**AB/74/21/L**

*11 Bond Street Arundel BN18 9BL*

*Listed building consent for the installation of conservation velux rooflight to rear outbuilding*

PROPOSED ELEVATIONS AND FLOOR
PLAN

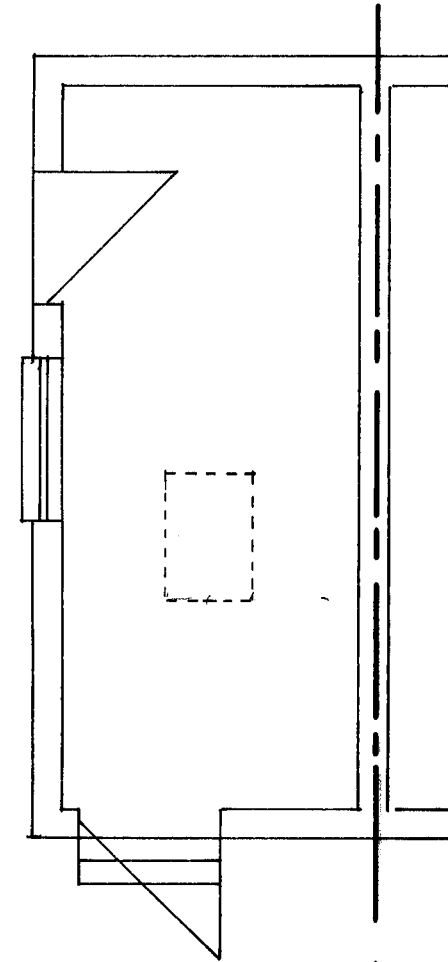
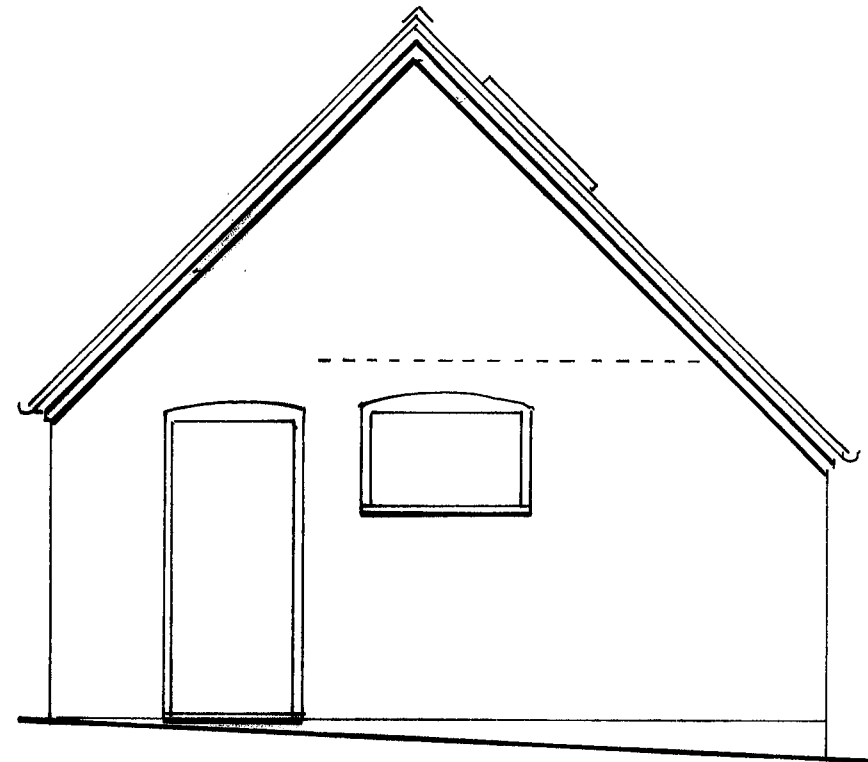
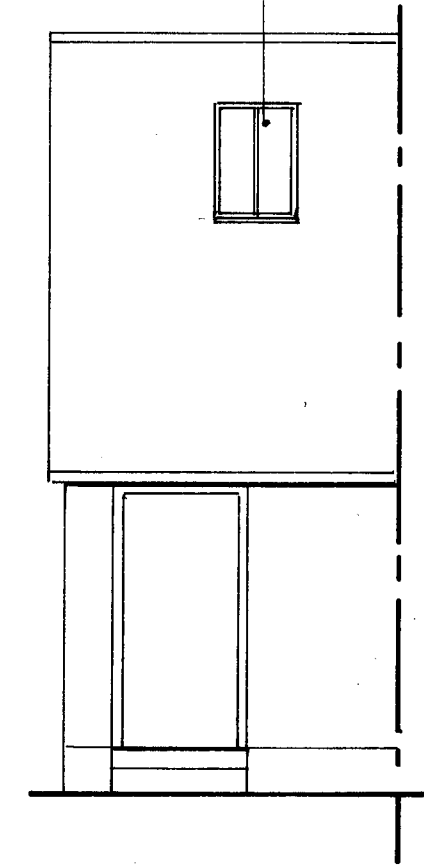
The proposal is for the installation of conservation Velux rooflight to the rear of an outbuilding. Historic mapping indicates that the outbuilding is a later addition and is present by 1875. It therefore forms part of the development of the terrace.

The proposed conservation roof light is of an appropriate size and location. It is not visible from the local road network and other houses within the terrace already have something similar fitted. As a consequence, I am of the opinion that the rooflight will not harm either the listed building or the conservation area.
